PLANNING BOARD REPORT PORTLAND, MAINE

MMC Surgical Facility Addition

Level III Site Plan, Conditional Use and Amended Site Location of Development Act (SLODA) Review Project ID # 2013-130

Submitted to:	Prepared by: Jean Fraser, Planner
Portland Planning Board:	Date: July 5 th , 2013
Public Hearing Date: July 9 th , 2013	Planning Board Report # 30-13

D4 OVERALL NORTH ELEVATION
 1/8" = 1'-0"

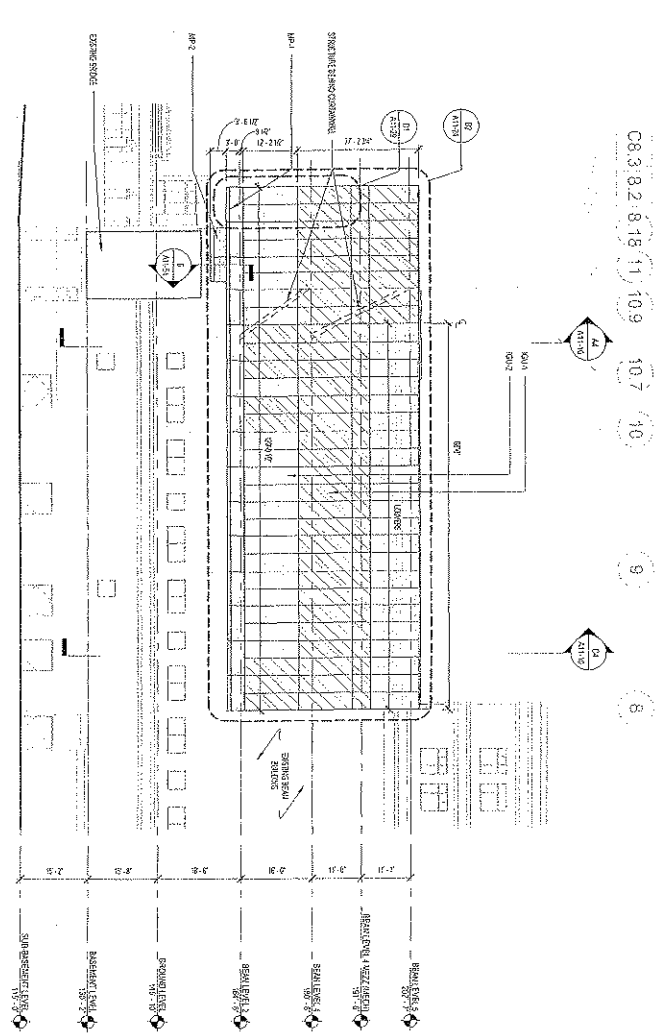
- Concern about adverse impacts of reflectivity (from sun) generally; would like rendering that shows reflectivity of louvres and metal panels (accurately in comparison with the glass/fritted glass) on the north elevation. The applicant has submitted an analysis of the proposal and how its glass specification, together with its orientation, reduces reflectivity impacts (Attachment U). This analysis includes a photomontage of the north elevation as viewed from the airport runway which is included in the information sent to the FAA (as per Attachment P.9). The question regarding the reflectivity of the louvres and metal panels has been addressed in the MMC letter in Attachment N.2 and samples of the materials will be available at the hearing.
- c. Such impact differs substantially from the impact which would normally occur from such a use in that zone.
